Commitment Letter

**Project Name: Sedona Sun Acres Subdivision, Filing #1**

**Description:** Sedona Sun Acres Subdivision, Filing #1 is proposed with three (3) residential lots. This approximately 38.6 acre subdivision is located southeast of Swan Road and Vollmer Road in Section 10, Township 12 South, Range 65 West.

SEDONA SUN ACRES FILING NO. 1

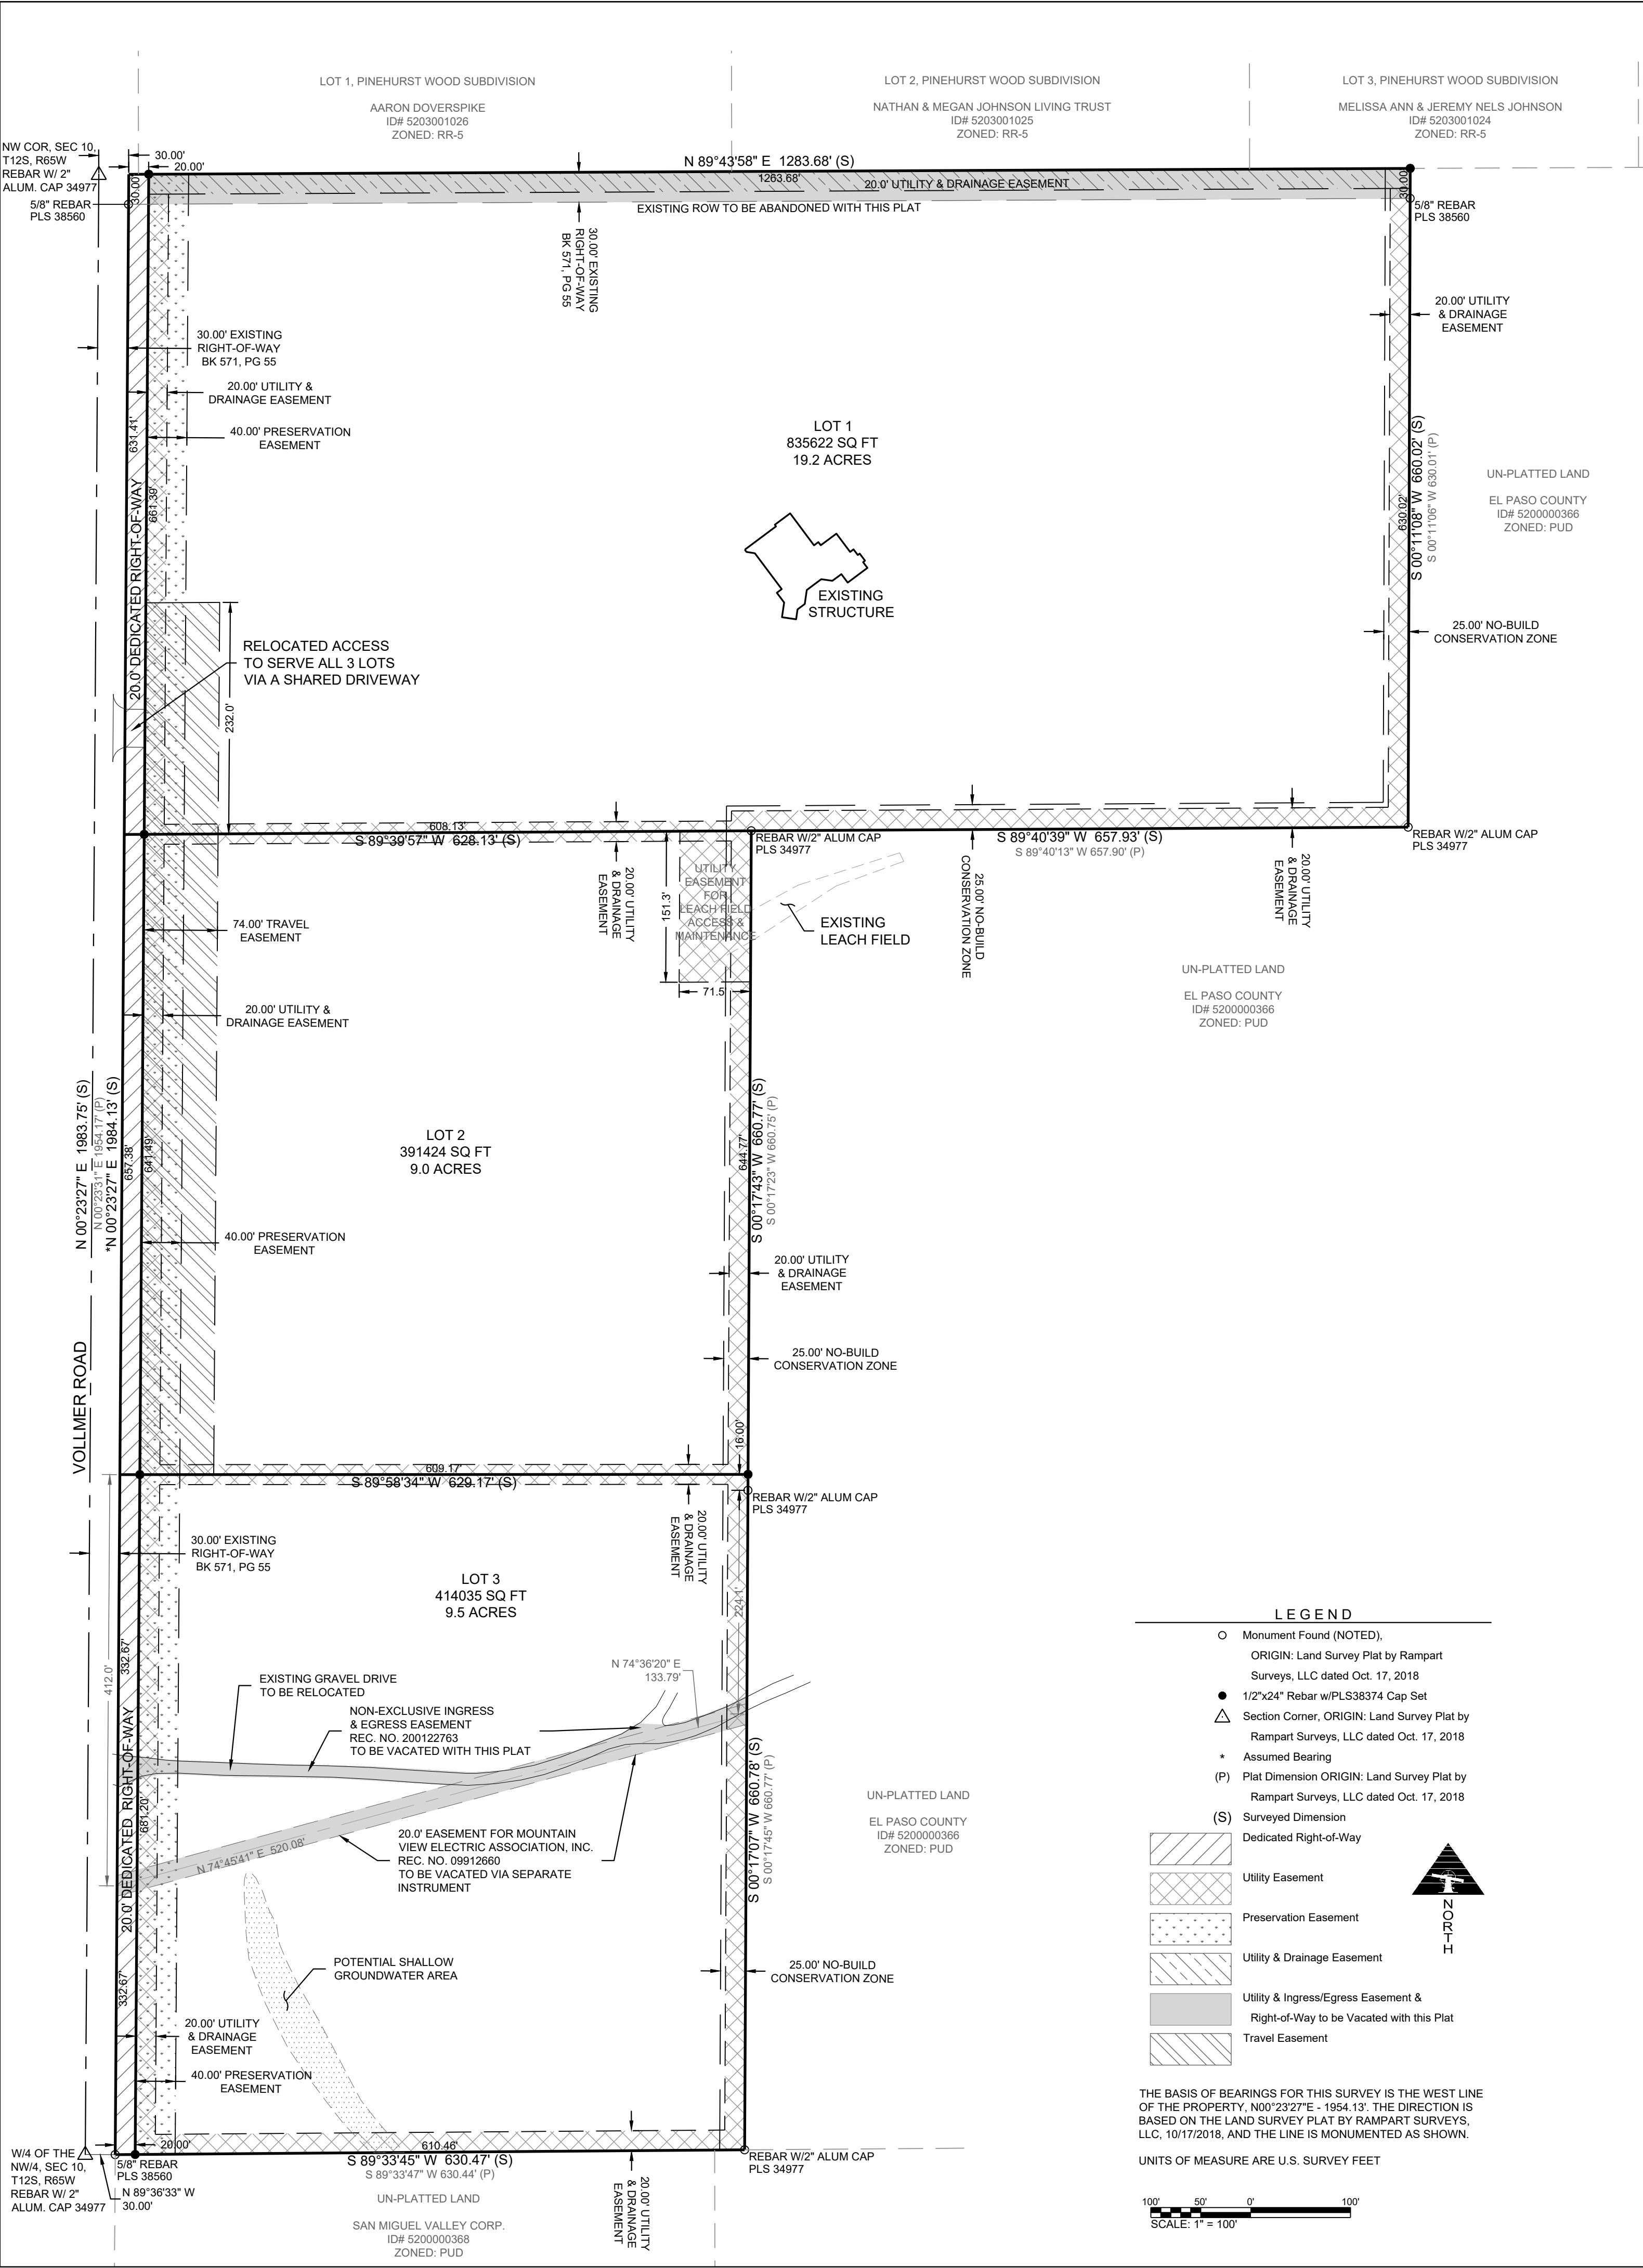
MVEA requests a ten (10) foot utility easement along all common side lot lines and a twenty (20) foot exterior subdivision utility easement. Additional easements may be required once a review of civil drawings with grading and erosion plan is provided to MVEA.
